24th November 2022

**Application No.:** 21/01630/OUT

**Proposal:** Outline planning application for up to 530 residential dwellings (within Use Class C3), open space provision, access, drainage and all associated works and operations including but not limited to demolition, earthworks, and engineering operations, with the details of appearance, landscaping, layout, and scale reserved for later determination

**Location:** Land at North West Bicester  
Home Farm, Lower Farm and SGR2  
Caversfield

Drawing Title
Parameters Plan: Maximum building heights and footprint

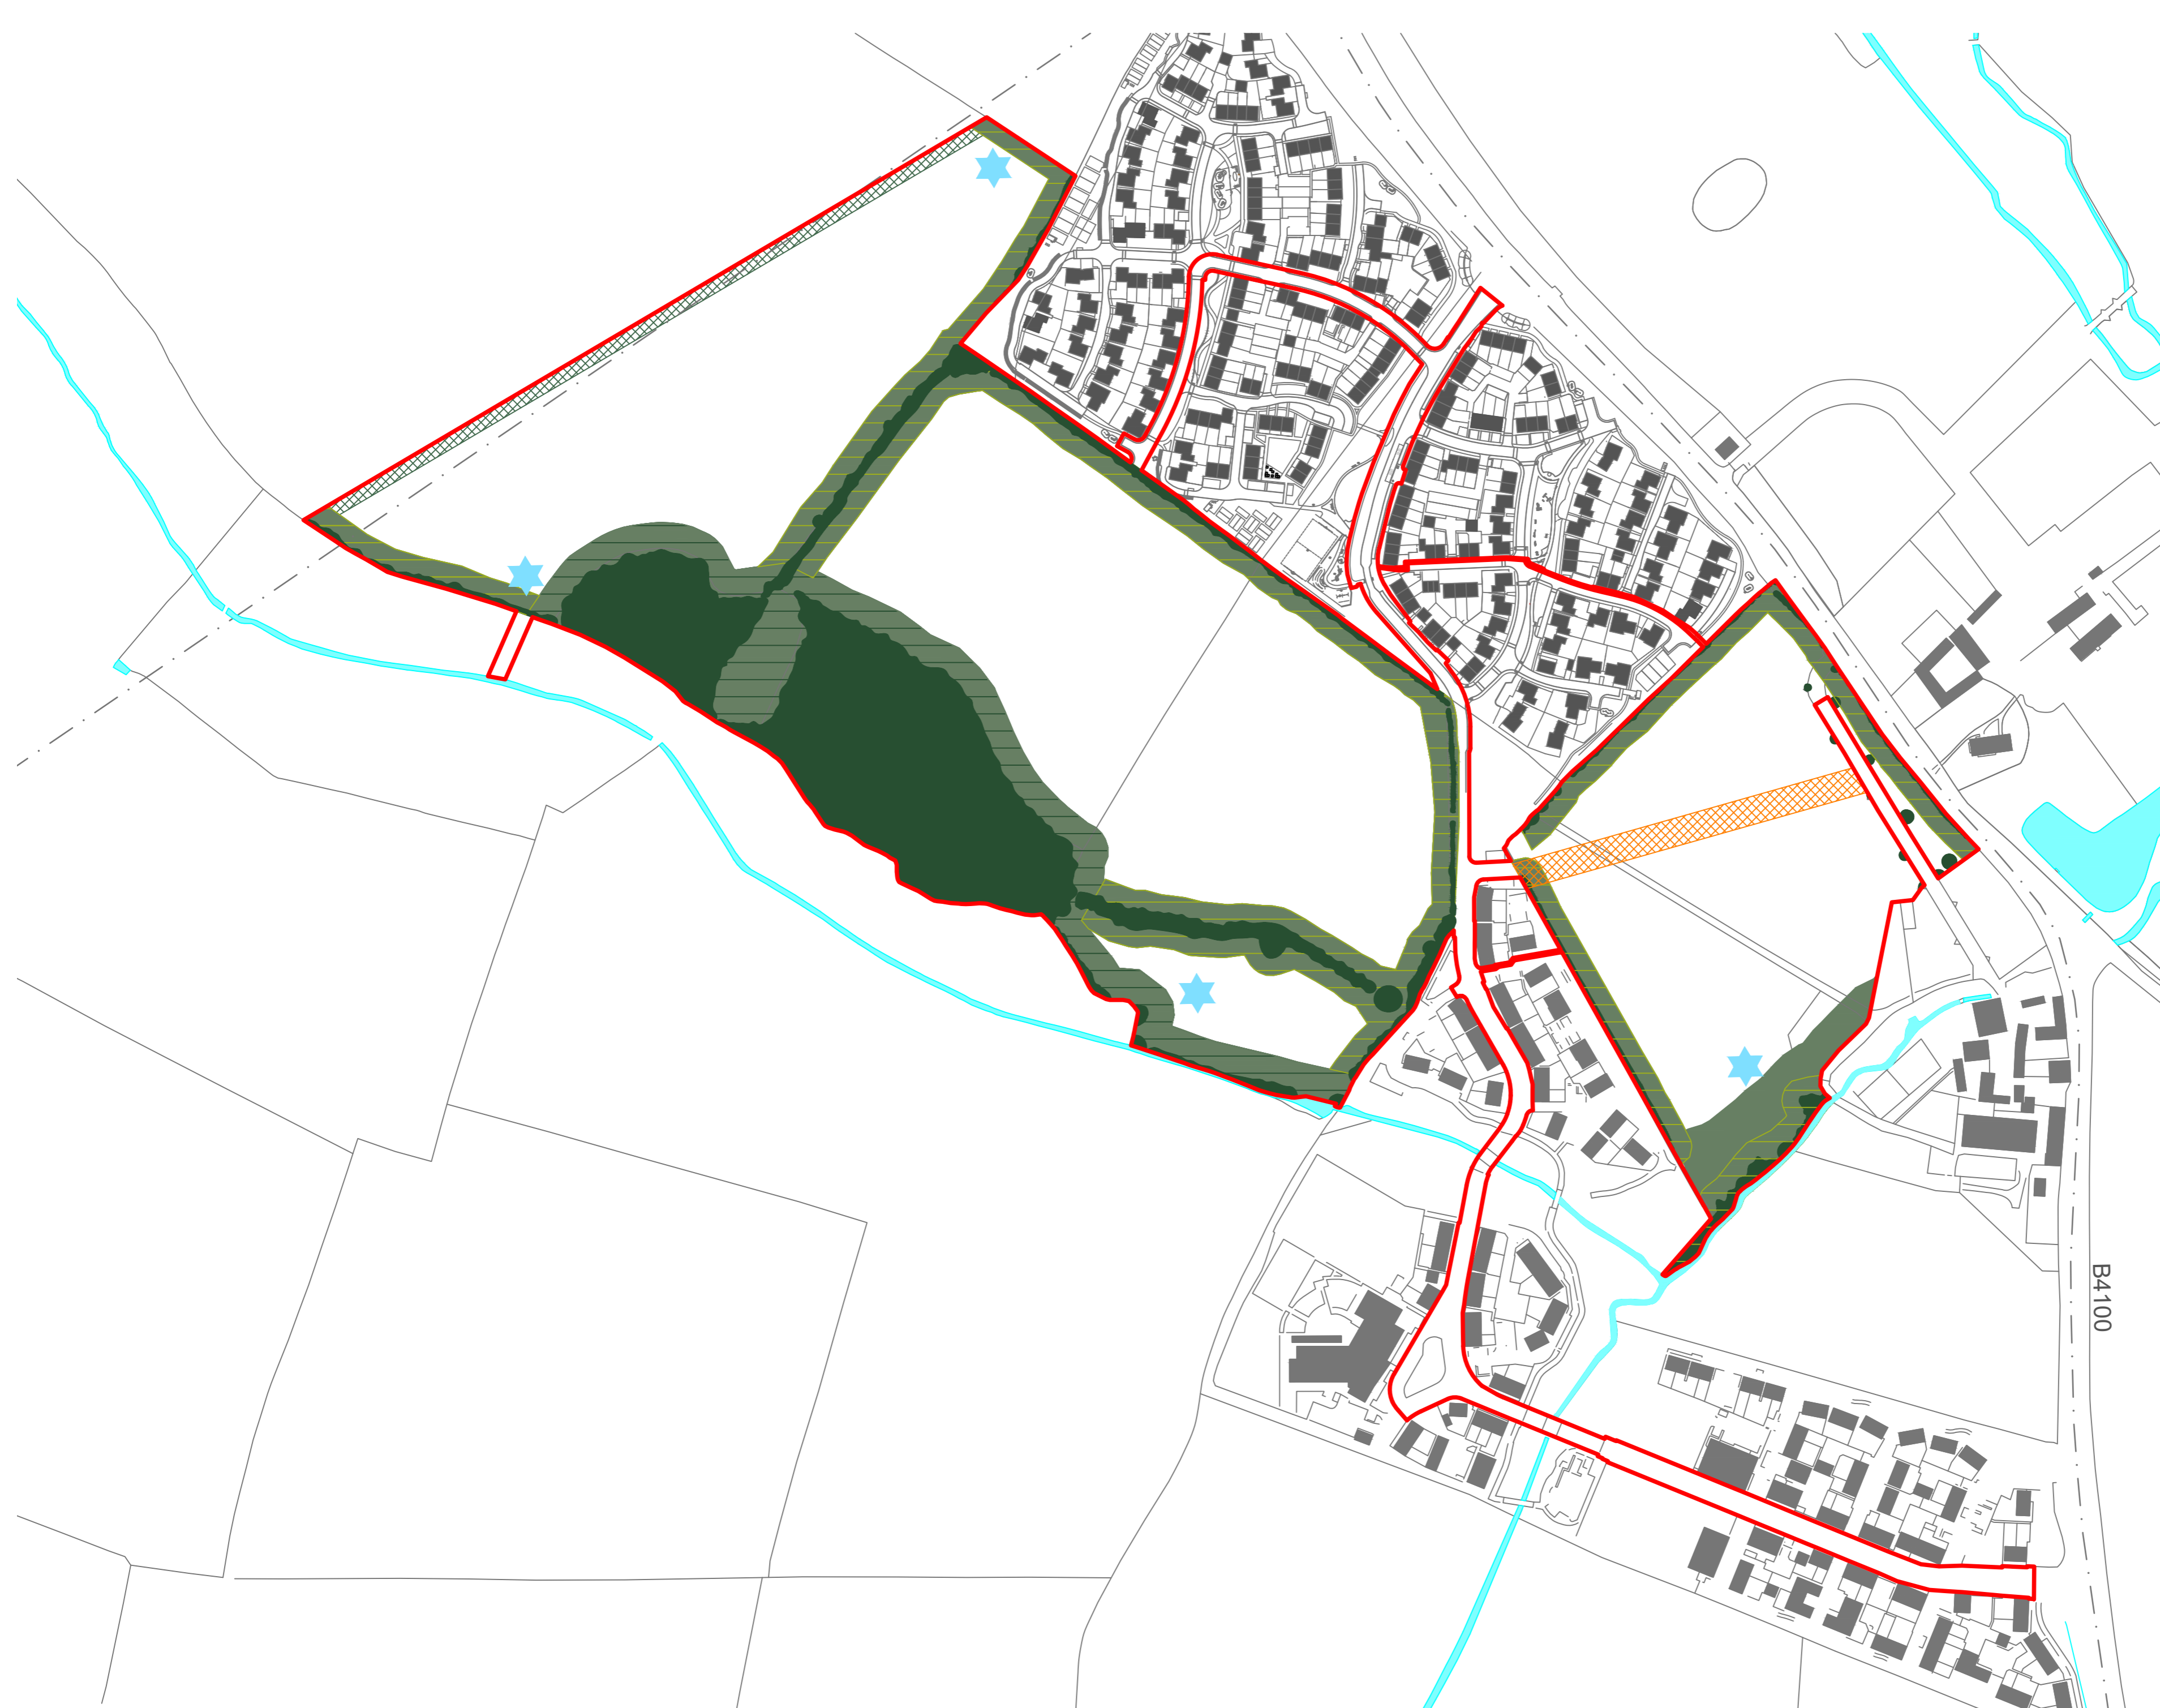
You will recall that through early discussions, questions were raised regarding the consistency of the parameter plans. This was discussed in quite some depth and your proposal was to deal with this matter via written explanation through a development parameters schedule document. In considering this matter in formulating the report as well as it having been reviewed by a colleague with experience elsewhere, it is concluded that the inconsistency of the plans is a matter that could result in a reason for refusal. This is because it would be difficult to resolve planning condition wording to deal with this matter, the plans remain inconsistent with each other, and they therefore do not form a suitable basis for the delivery of future reserved matter applications.

In addition, the proposal is EIA development and therefore it is critical that matters before the Council are correct and align with the submitted EIA. At this stage this is not the case. Any change to the parameter plans would be a matter that would likely require re-consultation under the EIA Regulations.
